CONSULTEE RESPONSE (Council's Arboriculturist)

Reference: A/102/22/PL

Proposal: 1 No new dwelling. This application is a Departure from the Development Plan and is in CIL Zone 3 and is CIL Liable as new dwelling

Location: Land rear of Oakhurst House and Huntington House, West Drive, Angmering

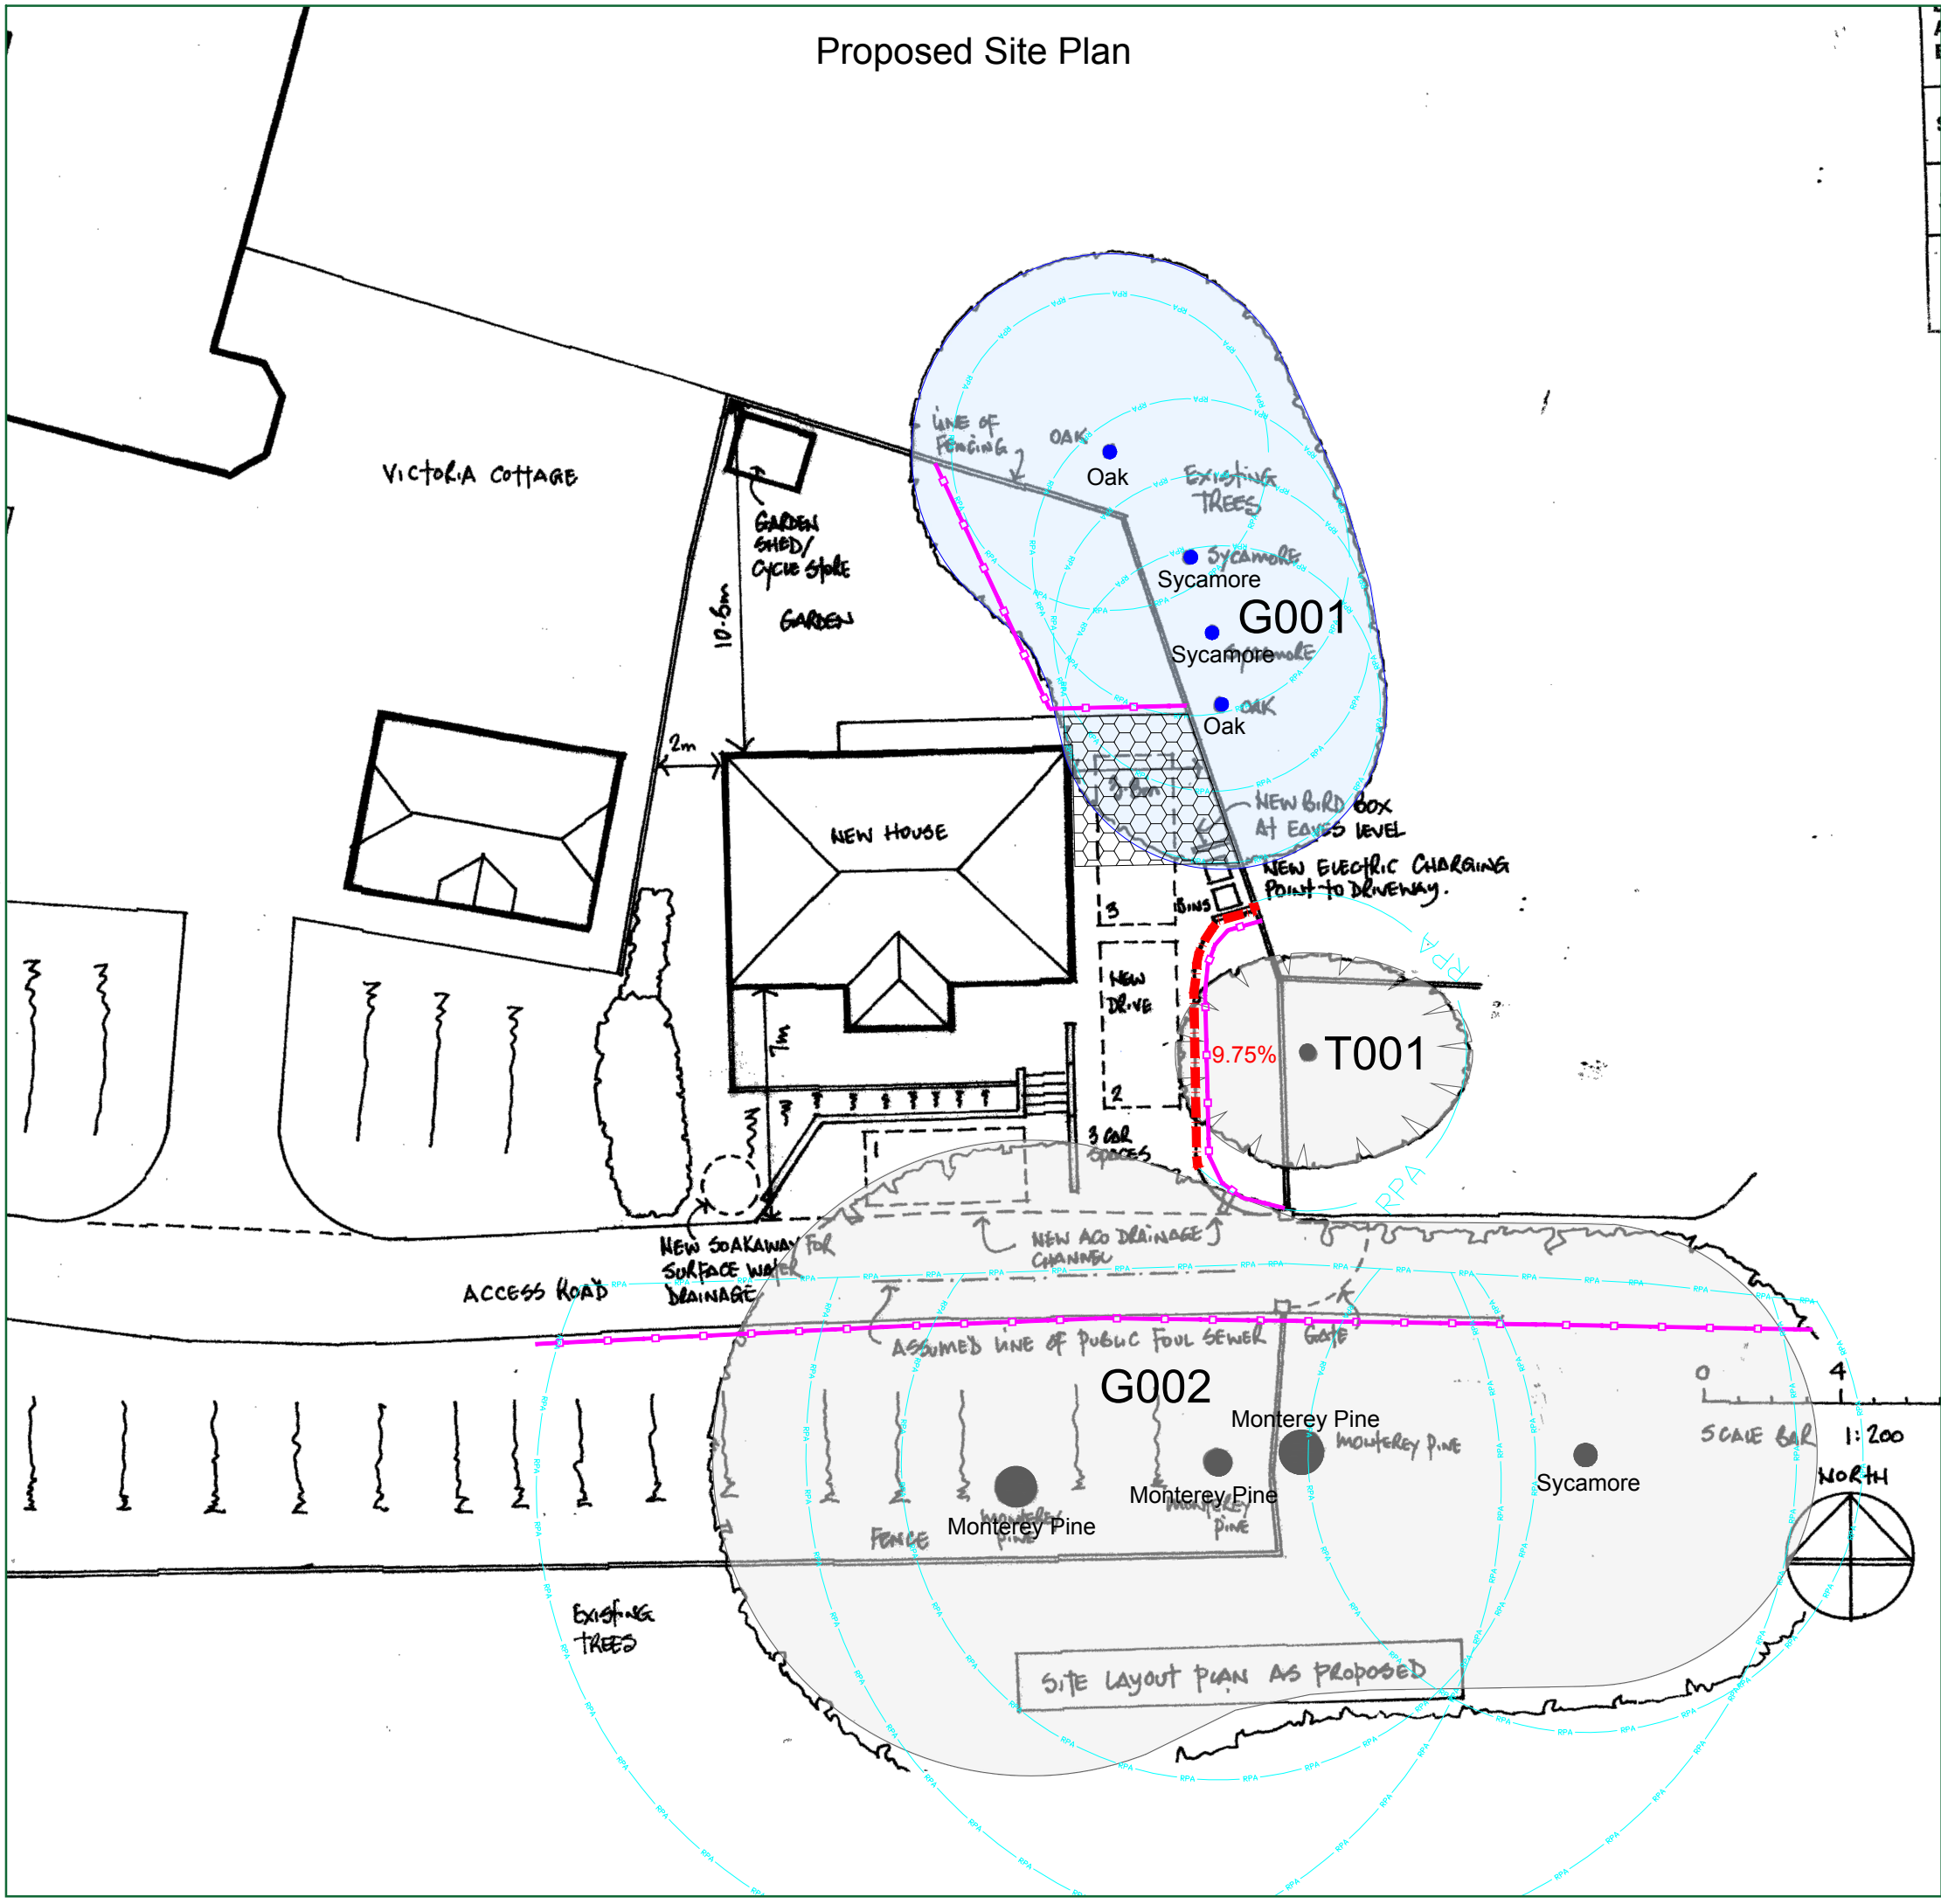
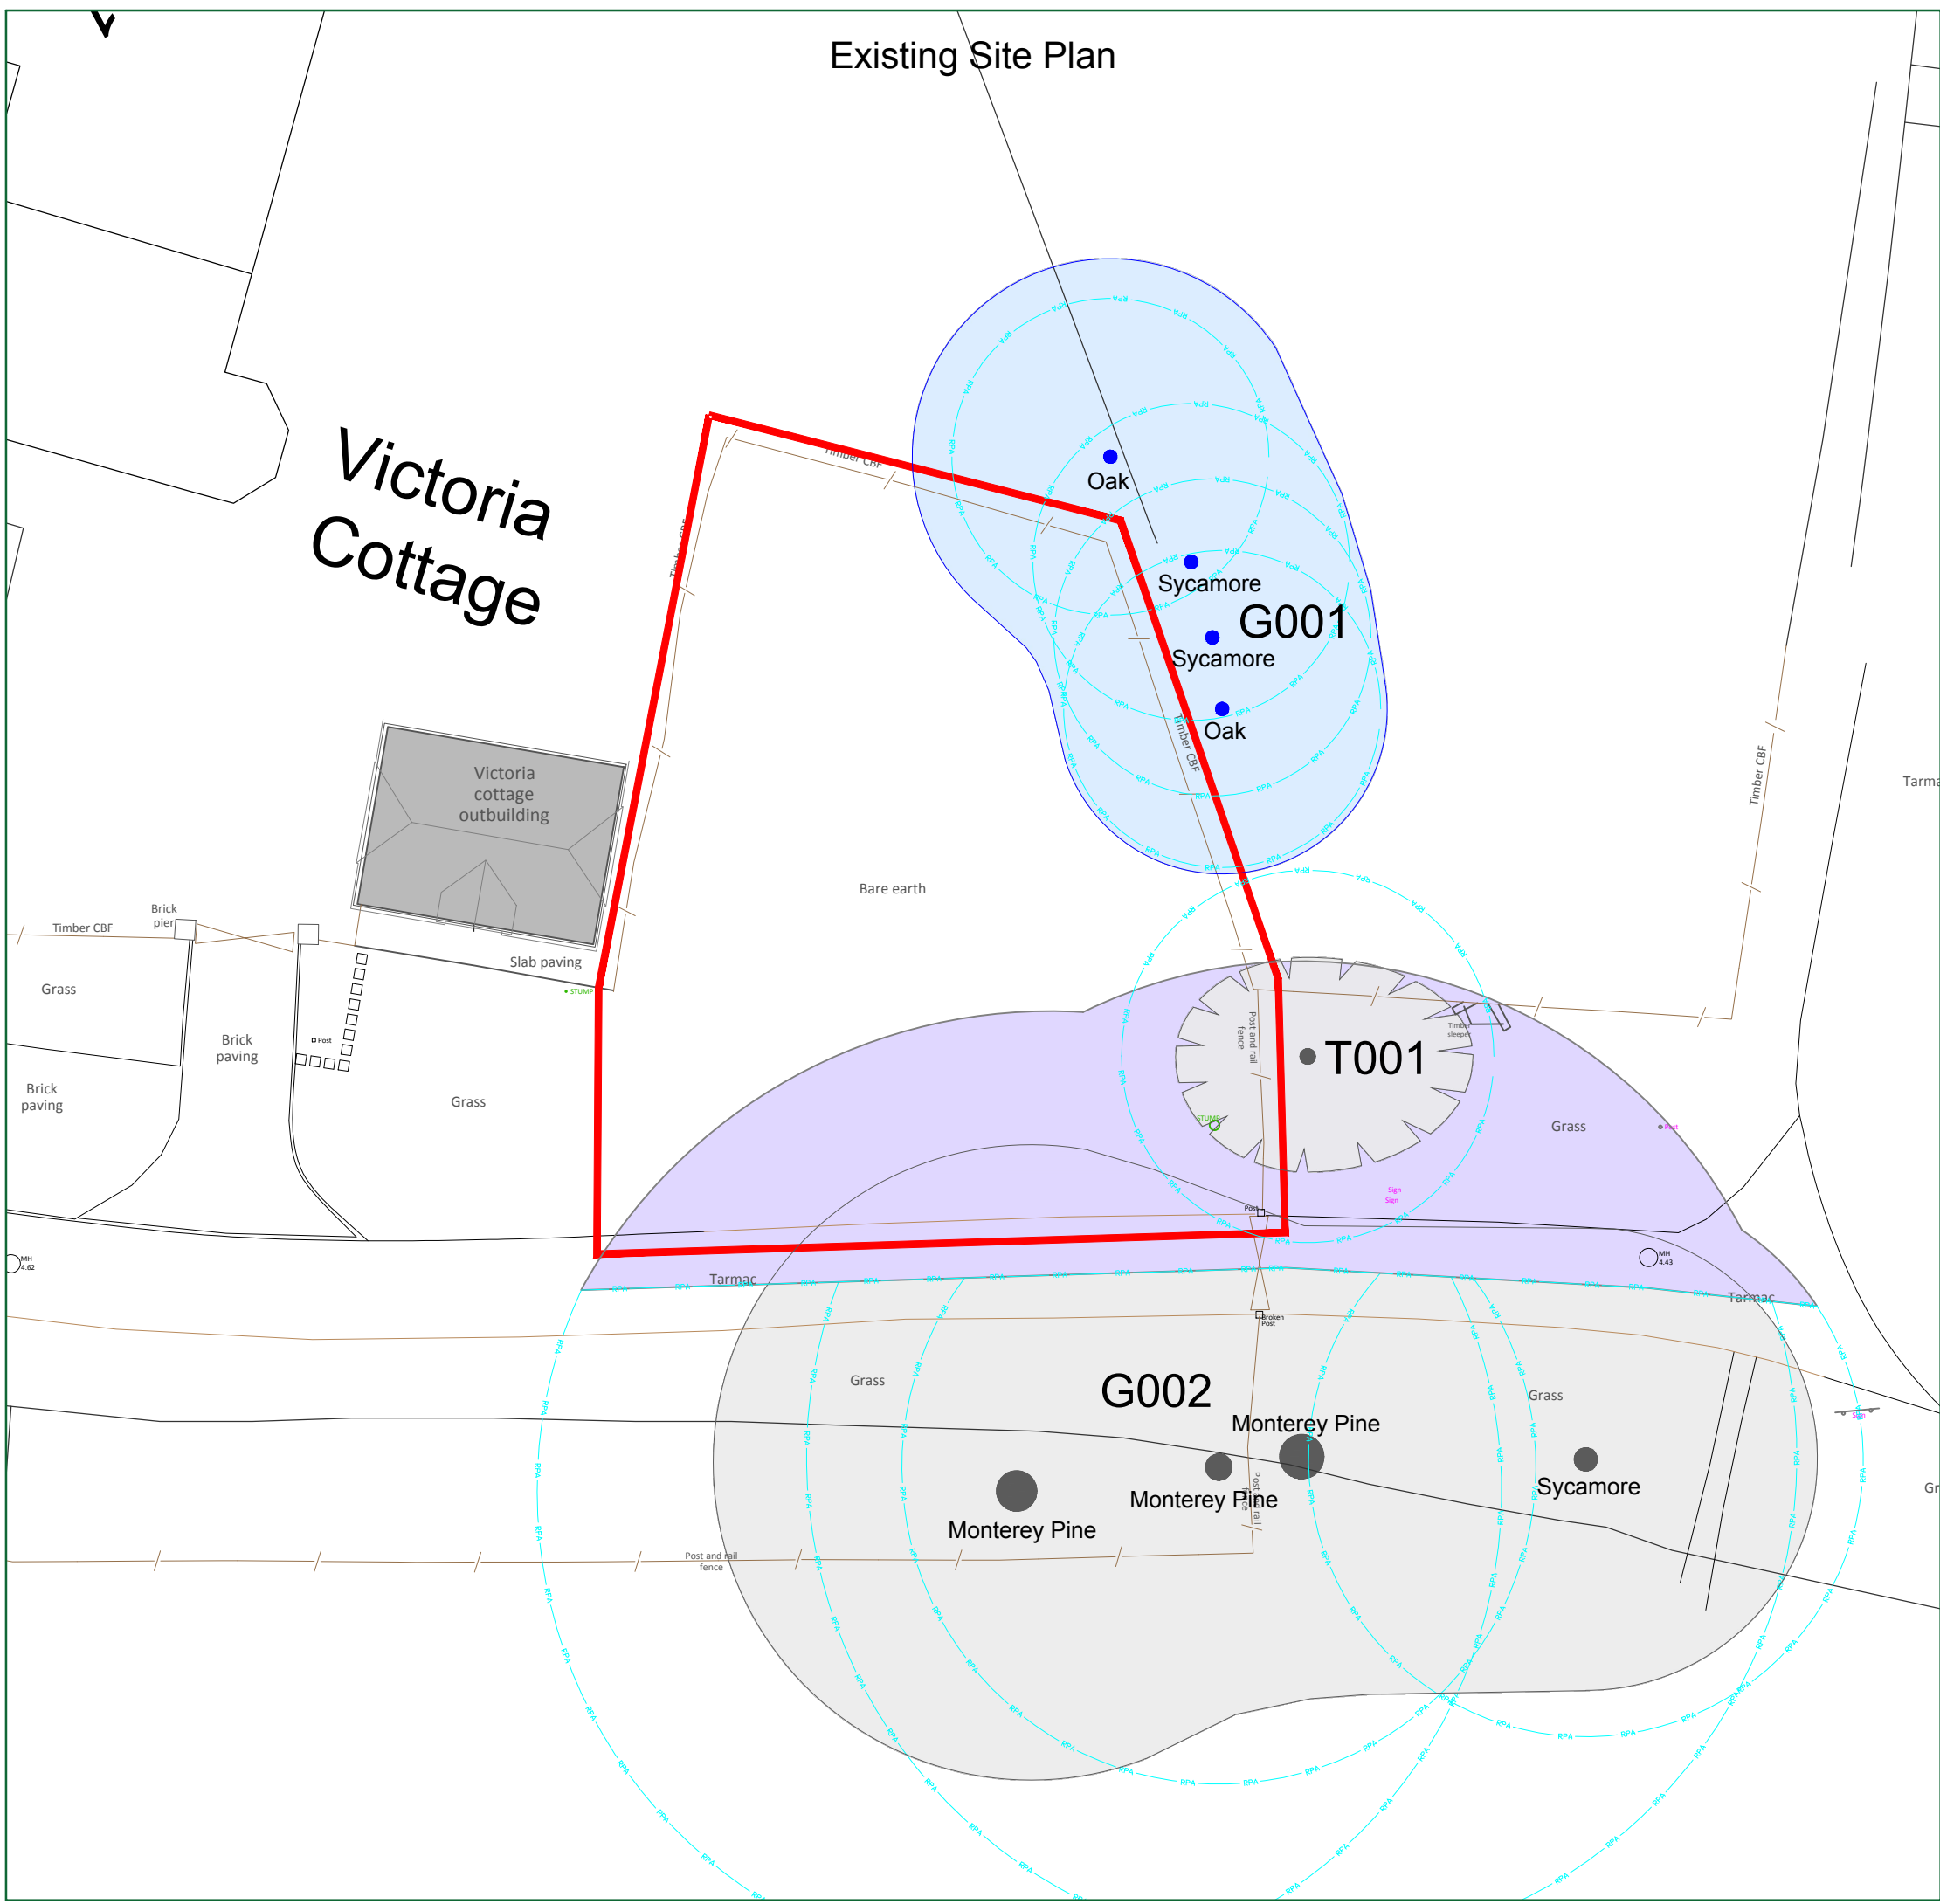
The relationship between ground levels of the proposed vehicle access and driveway ('no-dig construction') and adjacent areas has not been described in detail or shown on any cross-section drawing. The viability of this critical element of the development proposal must be revealed via civil engineering exercise, so we can be sure 3rd party preserved trees will not suffer damage and that finished ground levels in a broader context will be acceptable.

Construction is proposed within nominal root protection areas so a detailed Arboricultural Method Statement and Tree Protection Plan will be required to ensure those trees can be suitably protected throughout the development. The preliminary AIA&MS states as much, with the following areas of particular concern to be fully addressed prior to commencement:

Shading effect from off-site trees (G001) is likely to be tolerable although heavy deposits of leaf, seed and fruit will be a seasonal nuisance. They will exert considerable influence over rear garden conditions/potential and we should anticipate future tree work applications to control their height and spread which may be hard to resist if the scheme in current form is approved.

Before the site is occupied or any machinery is introduced to the site or demolition work or construction work or alterations to existing ground levels takes place, the applicant must submit a detailed Arboricultural Method Statement (AMS) and Tree Protection Plan (TPP) to the local planning authority for approval. Written confirmation of acceptance of both AMS and TPP must be issued before any works are commenced on site.
